Please ask for: Ms Iqraa Malik
Email: iqraa.malik@terraquest.co.uk
Telephone: 0121 234 1390
Our Ref: R/256/21/HH
Your Ref:
Date: 11th October 2021

Application for Planning Permission for Works or Extension to a Dwelling

Development: Erection of single storey rear extension following the demolition of existing rear conservatory
Location: 26 Westlands Rustington BN16 3NW

Site Block Plan

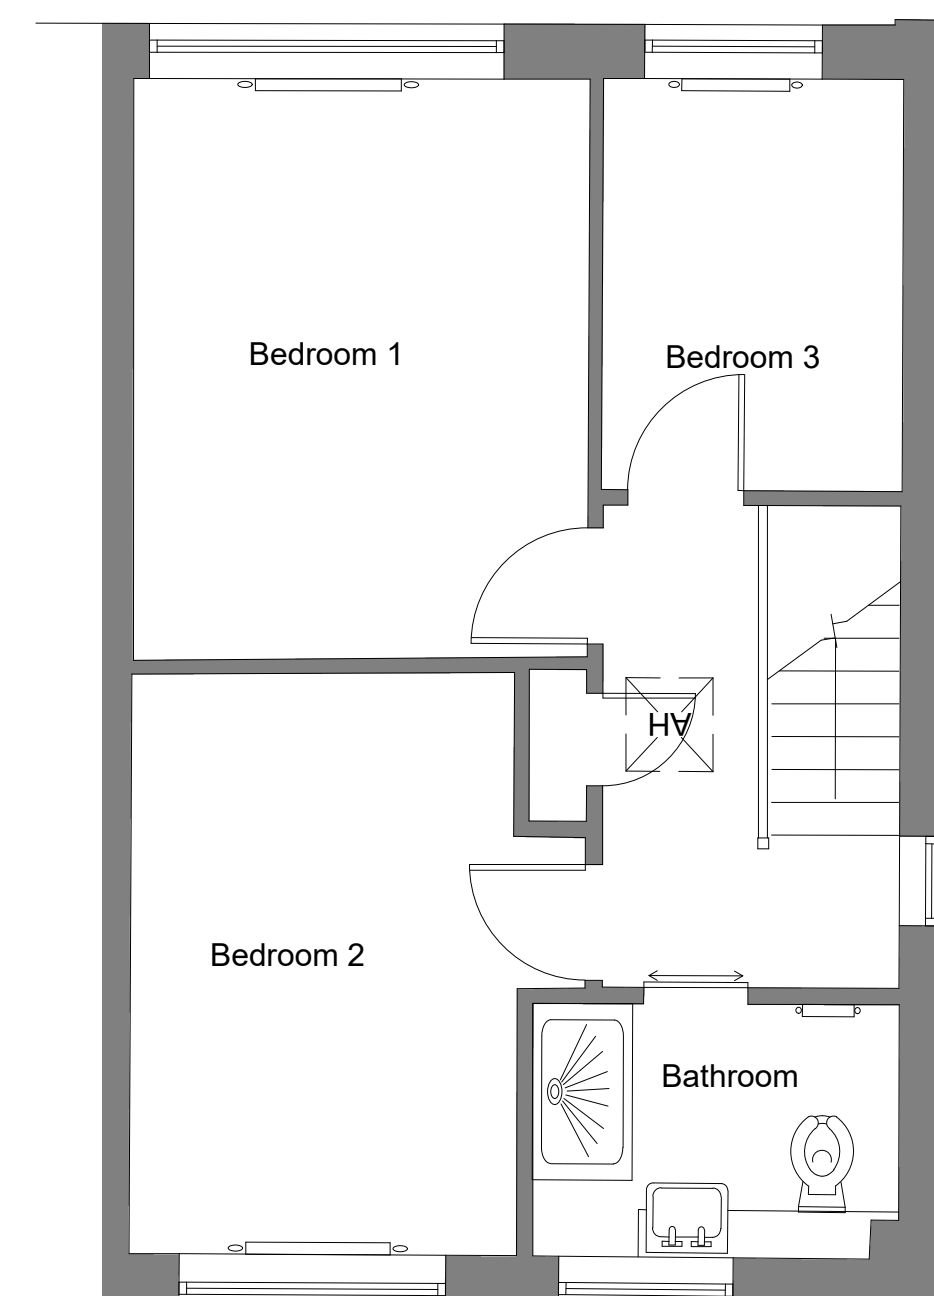
You are required to have dimensions from the proposed extension(s) to all site boundaries. Please amend.
